From: Simon Davis
Sent: 12 January 2021 16:23
To: Havis, Sean [REDACTED]
Cc: Sparkes, Jessica [REDACTED]
Subject: RE: *EXTERNAL: Y/127/20/PL Standalone Application for the Access

Are you able to provide an update on the decision for the full application for access at Drove Lane, Yapton (Y/127/20/PL) please?

Drawing Title
SECTION 278
GENERAL ARRANGEMENT
AND PROPOSED
LEVELS PLAN

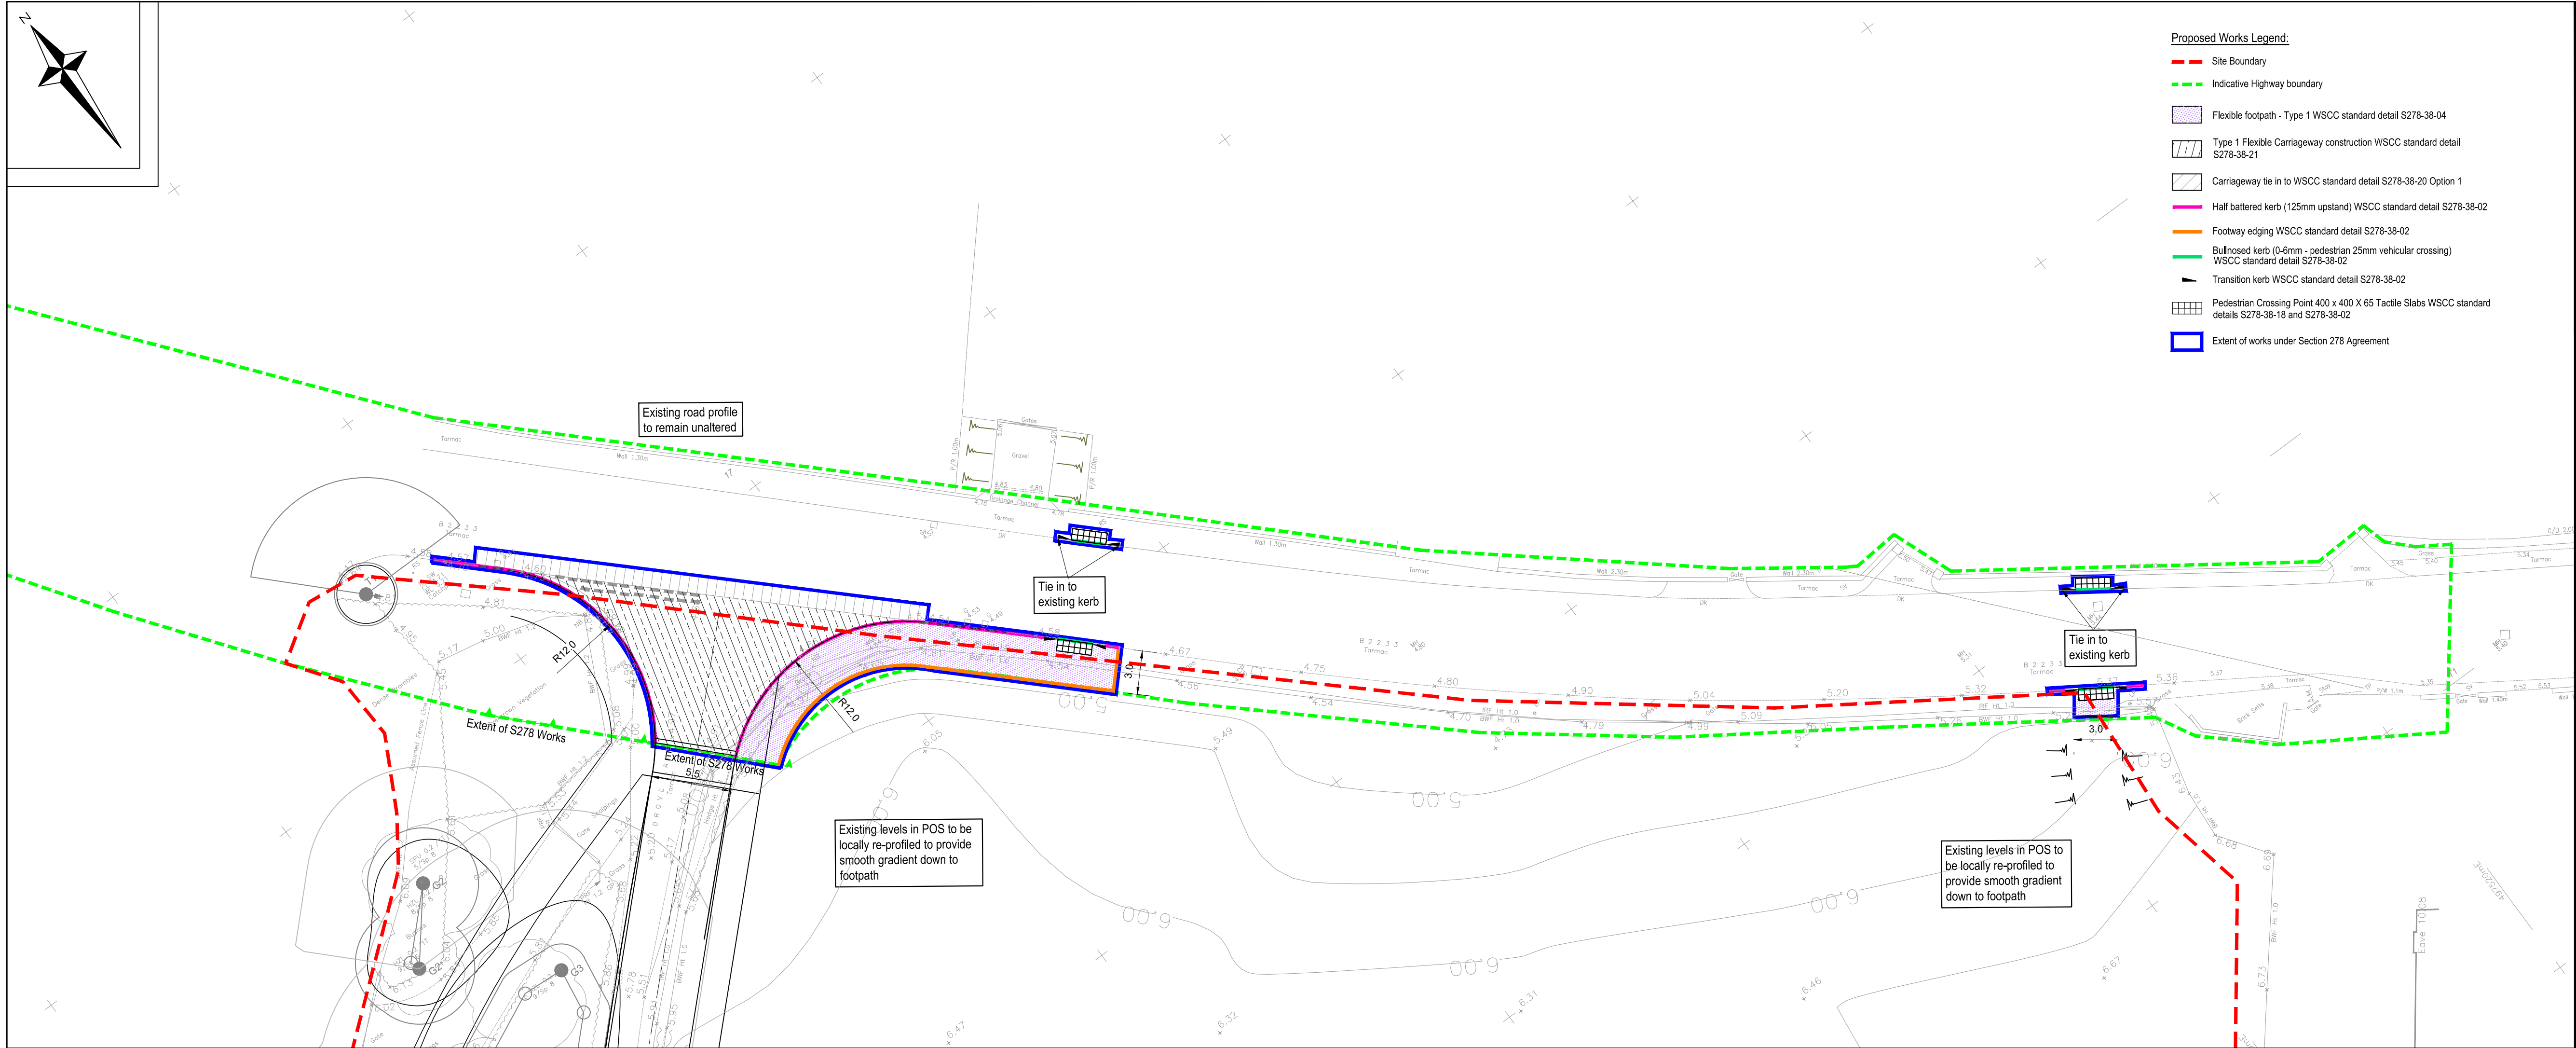
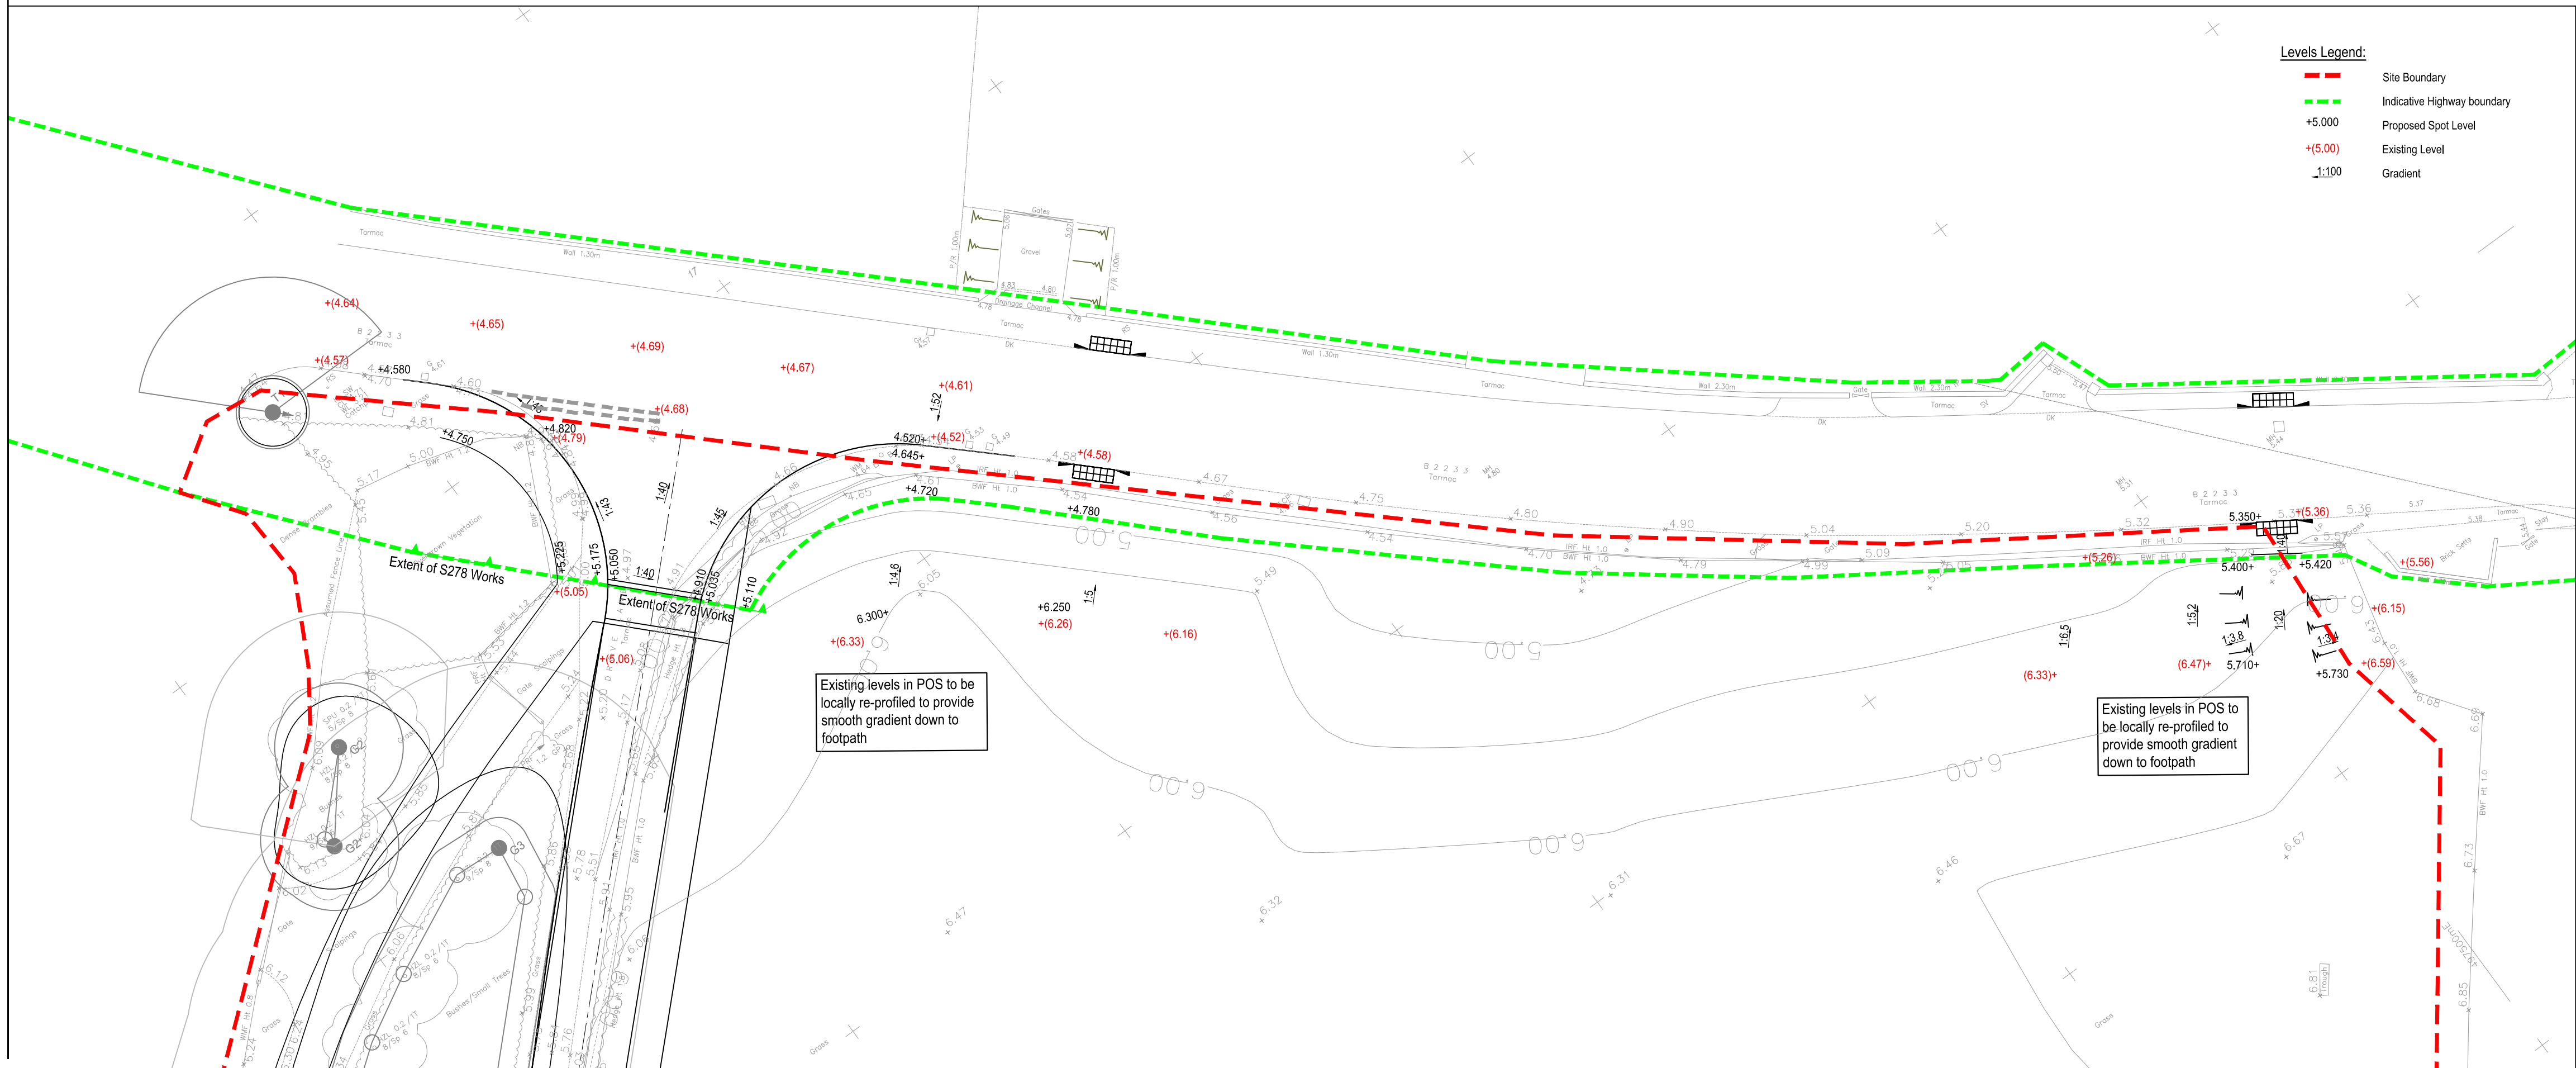
There is a concern that the access arrangements make no provision for cyclists to cross Main Road at the point where the cycle/footpath meets the highway (this point being directly opposite the vehicular access to the Bonhams Field site).

My feeling was that cyclists could safely cross the road by heading south at the end of the cycle path, crossing over Drove Lane and then using the tactile paved crossing point to cross over onto the pavement on the eastern side of Main Road. However, there is concern that cyclists, particularly children, will not do this and may instead just try to cross over straight into the Bonhams access with a risk of accident.

Pages 24-25 of the West Sussex Cycling Design guide does address the issue of the interface between the carriageway and a cycle path. It states that cyclists should not have to dismount to cross roads and that barriers should only be provided where there is a need and it recommends that a single bollard is sufficient.

Is there a reason why you have deviated from the alignment of the cycle path as shown on the outline access plan? This previously showed the cycle path meeting the carriageway with two bollards (attached for ease). That arrangement would still have been opposite the Bonhams access but does better meet the Cycling Design guidance.
